KITTTITAS COUNTY COMMUNITY DEVELOPMENT SERVICES

RE: Chimpanzee Sanctuary Northwest SEPA (SE-18-00005)

Community Development Services (CDS) on May 31st, 2018 issued an Addendum (attached) to a Mitigated Determination of Non-Significance (also attached) issued on August 1st, 2016 in regards to the driveway relocation under the Washington State Environmental Policy Act (SEPA). Agencies with jurisdiction and interested members of the public were given opportunity to comment on the proposal. The comment period ended June 15th, 2018. The following comments were received, and are attached:

Subject: SE-18-00005 – Northwest Chimpanzee Sanctuary
SR 10 milepost 91.1 left

# CRITICAL AREAS STUDY MAP

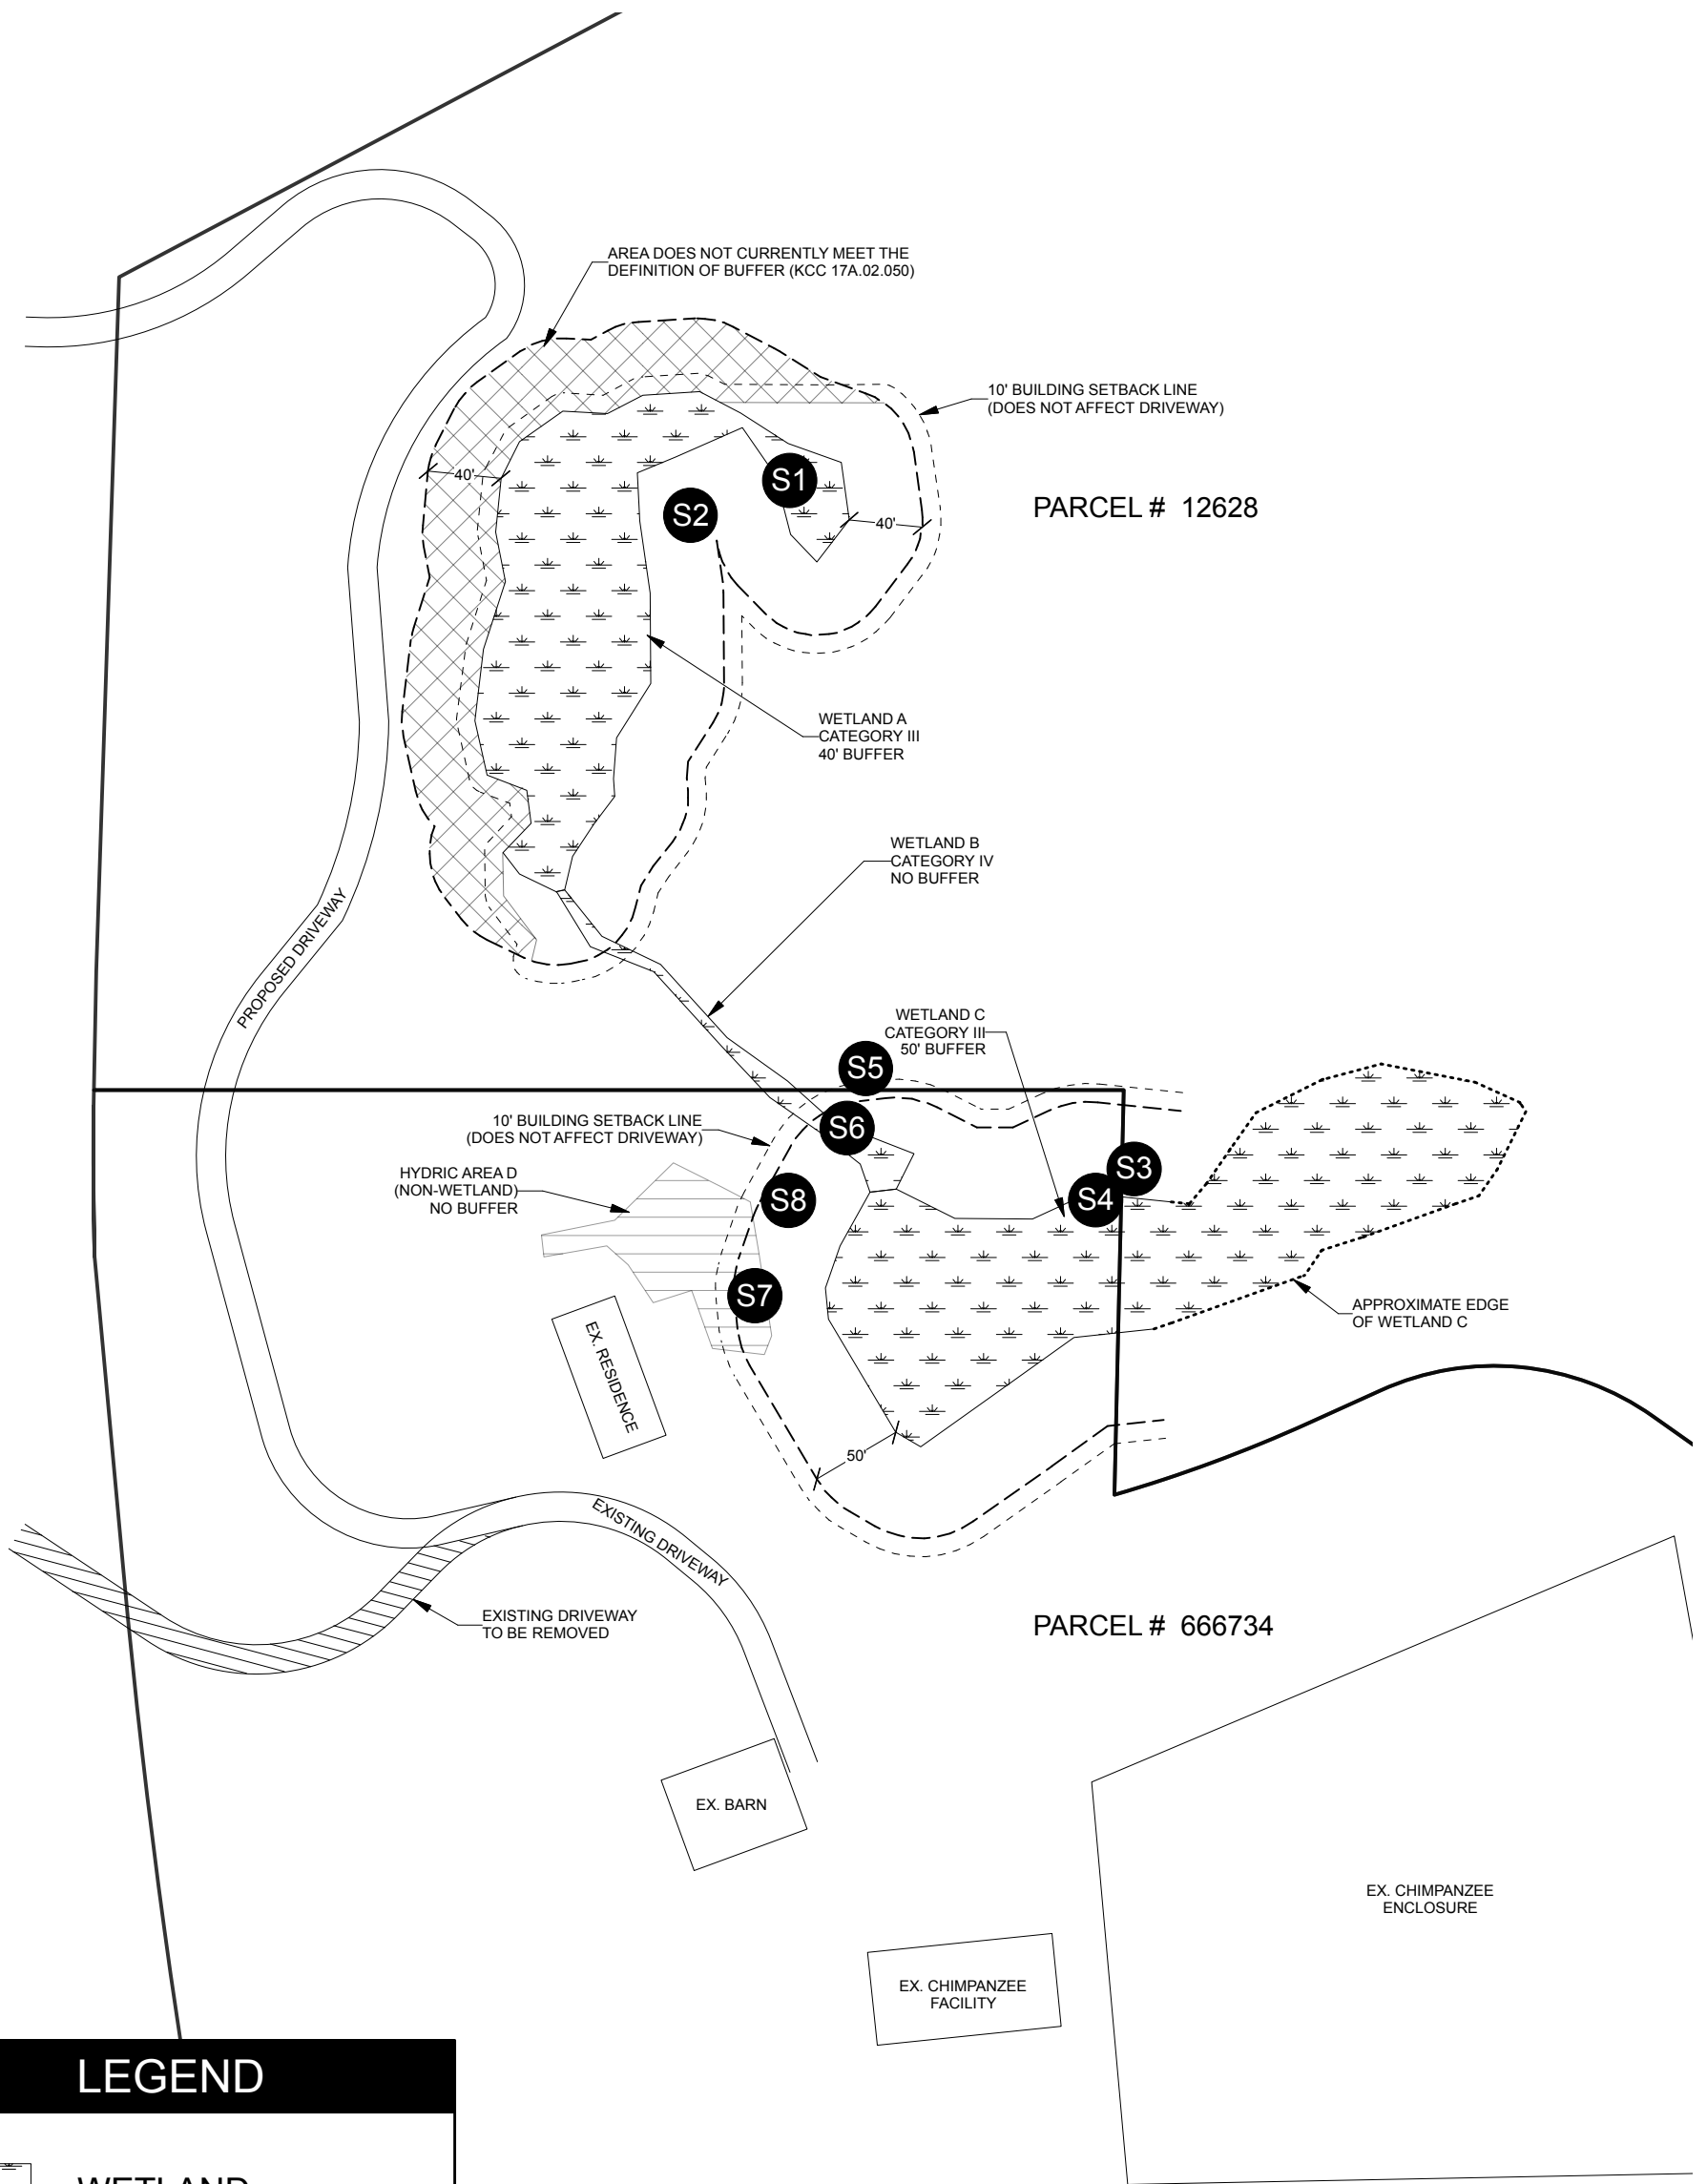
Kittitas County's Critical Areas Code, 17A.04.020, Wetland Buffers, recommends a 20 to 80 ft. wide vegetated buffer surrounding Category III wetlands. The Department of Ecology recommends the County request an 80' wide buffer surrounding each of the Category 3 wetlands. Ecology's recommendation is based on Best Available Science (BSA), our interagency guidance documents, the Habitat score of the previously reviewed wetland ratings, existing landuse intensity, the location of the site, and use of corridors in the area.

Ecology would require a 110' wide buffer for Category 3 wetlands that have a moderate Habitat score and a moderate intensity landuse. The existing landuse is considered either a moderate or high landuse intensity, due to the keeping of animals and regular maintenance. Ecology's buffer guidance documents assume the existing buffer is vegetated. The area surrounding Wetland A appears to be highly disturbed and lacks vegetation. The buffer width should be vegetated prior to the installation of the driveway. Without a planted buffer the driveway should be located even further away from the wetland. Planting the buffer will reduce noise, dust and other pollutants from entering the wetland, and provide structure adjacent to the wetland. The driveway should be located a minimum of 80' landward of the wetland boundary with at least 40' of it vegetated.
